Submission ID: 34868

Jonathan Tennant on behalf of the Aldington and Mersham Support Group

ISH 3 on 25th February 2025 - PROW

- Notes:**
- All hedgerow reinforcement planting to be done within the DCO boundary.
- Legend:**
- ORDER LIMITS
 - EXISTING SURVEYED TREES AND VEGETATION
 - EXISTING WATERCOURSES AND FEATURES

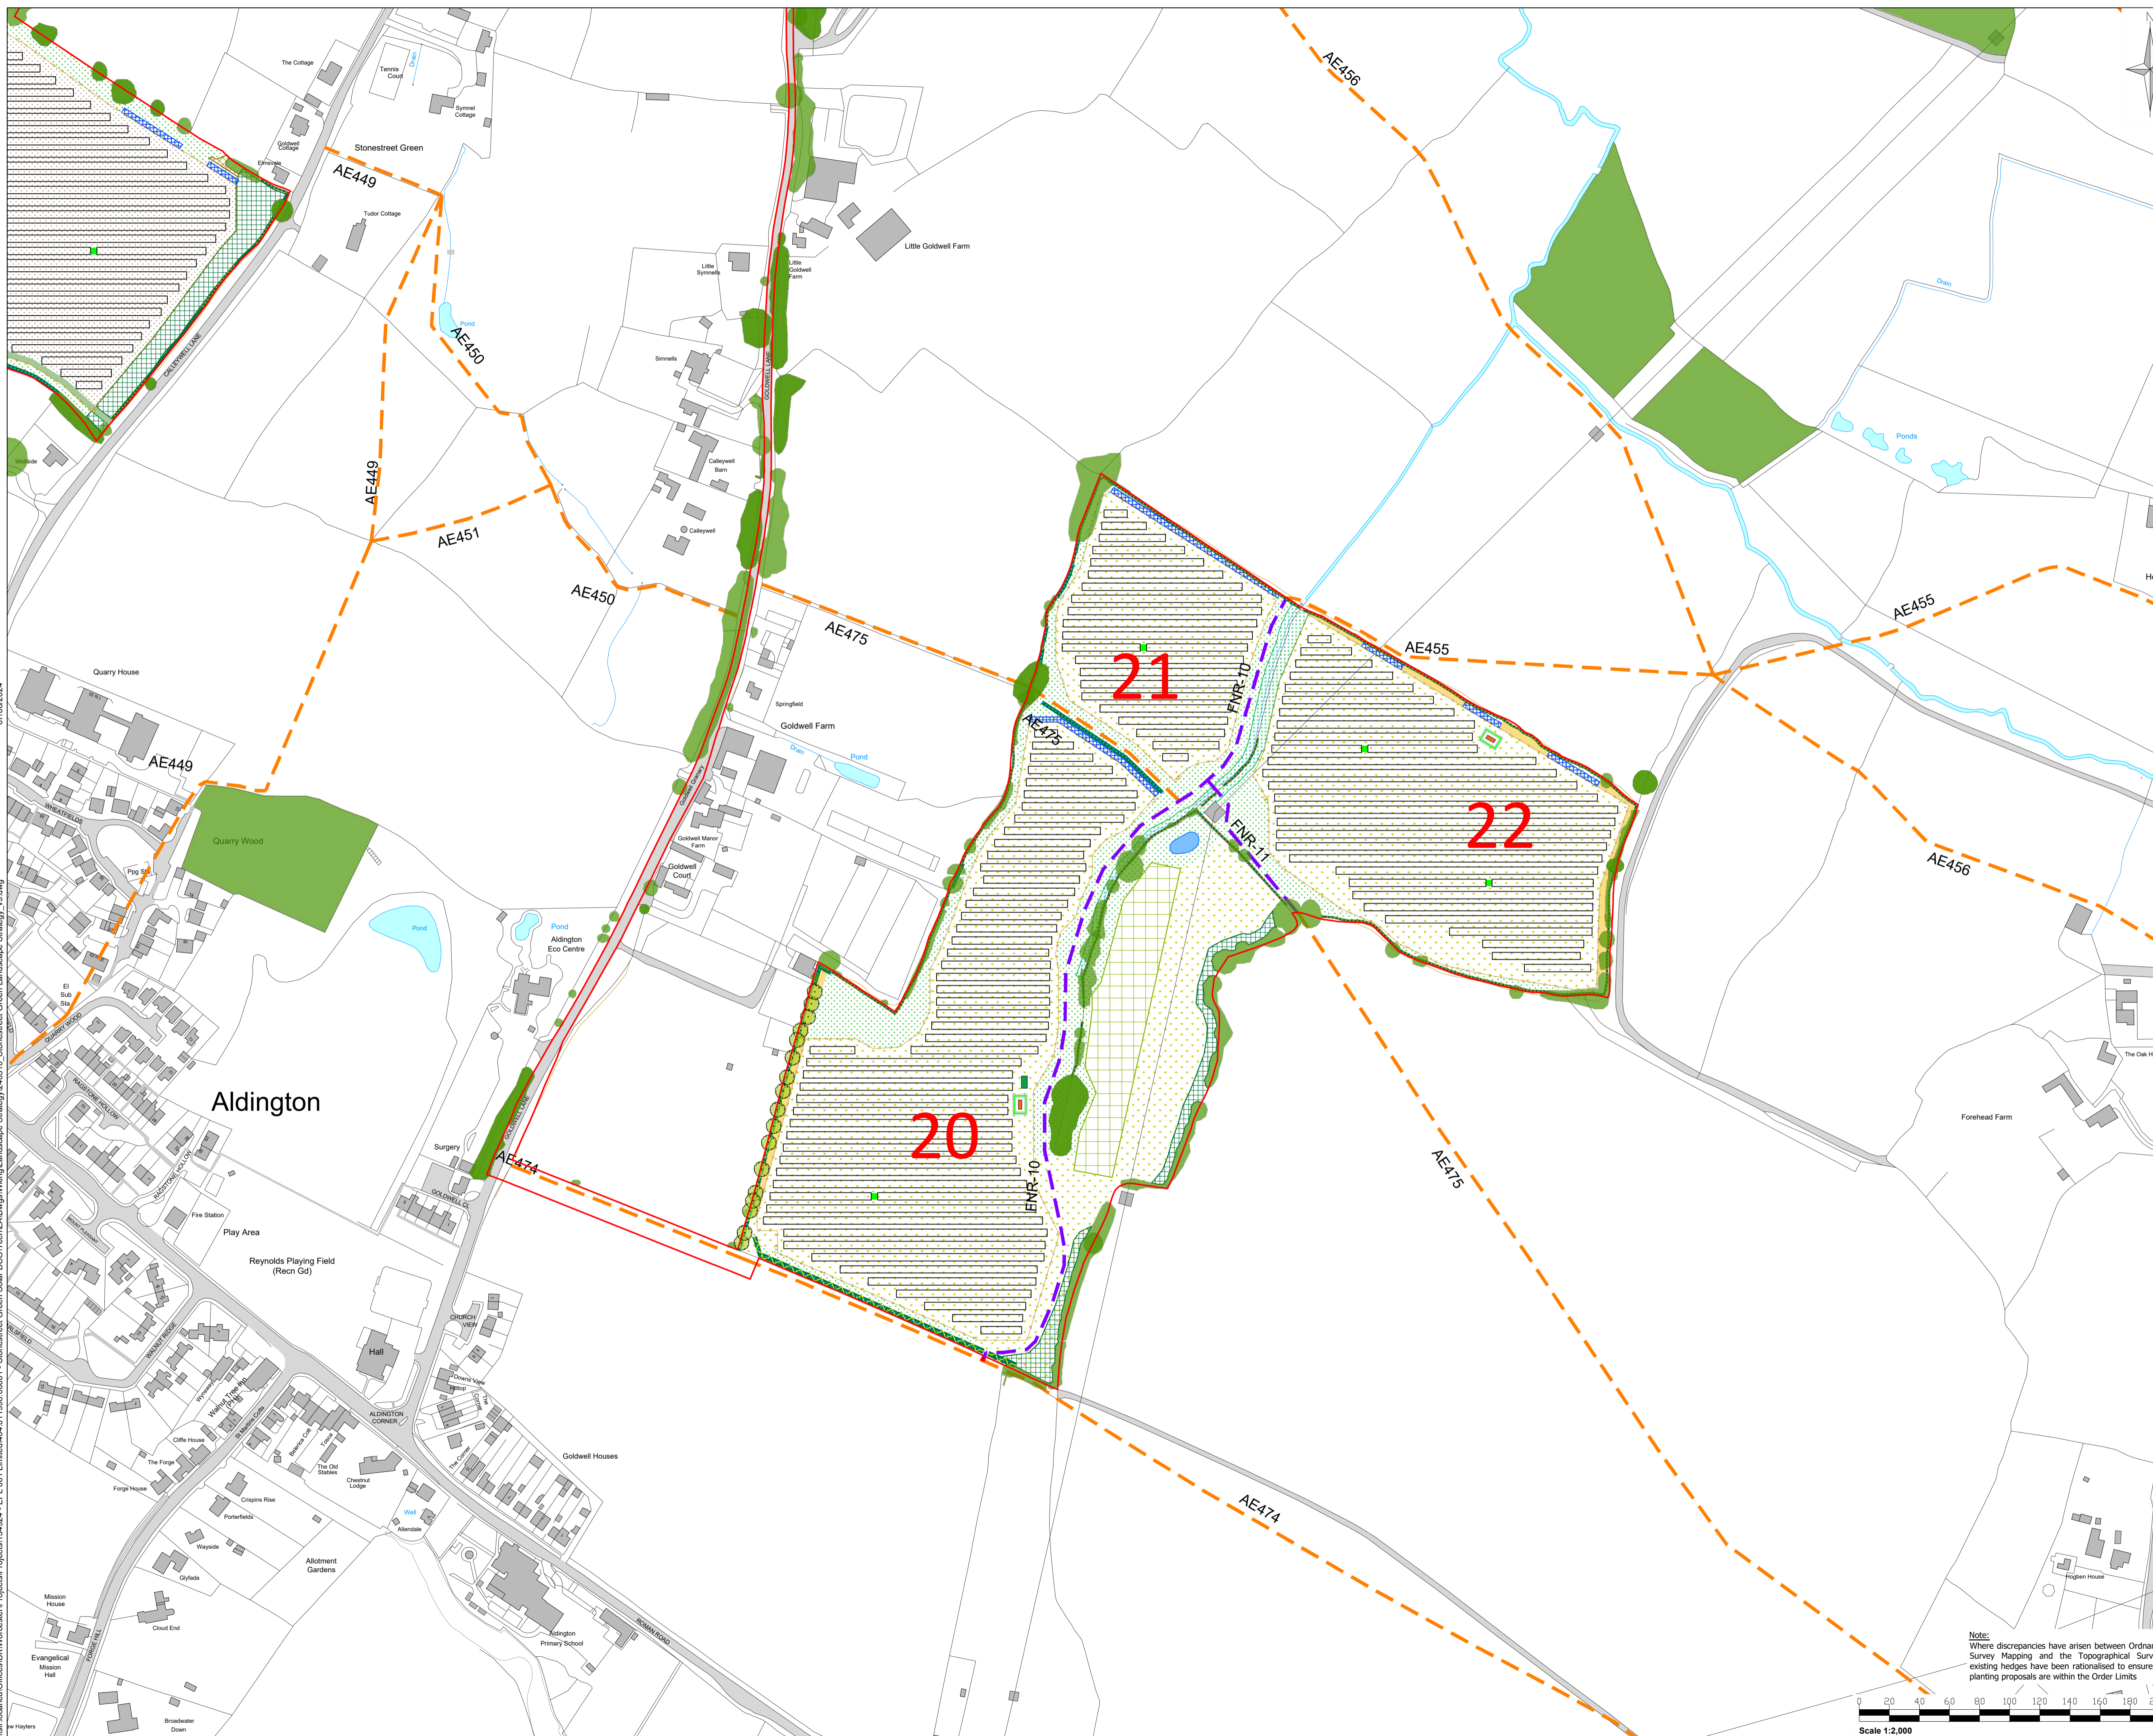
I would like to focus on just one aspect today. I have studied the illustrative plans submitted by the applicant reference **APP 013** and like others reviewed the numerous proposed diversions. Many of these changes are significant, circuitous and, in all cases will diminish enjoyment. Put bluntly, the new setting of nearly all of the paths within the red line boundary will be so bad that it is doubtful people will wish to walk any of them in the future.

What is so striking when looking at the illustrative plans is not only the angular and laborious diversion of many footpaths but the fact that the logical mitigation of planting hedges adjacent to the security fencing is almost non-existent. Across nearly 500 acres of development, I can only find evidence of this happening for short distances notably in fields 2, 18 and 21. Field 18 is adjacent to Calleywell Lane where there will be some native tree planting beside new footpath FNR 5 for about 150 metres heading out on what will be a new, longer and very circuitous route towards Mersham.
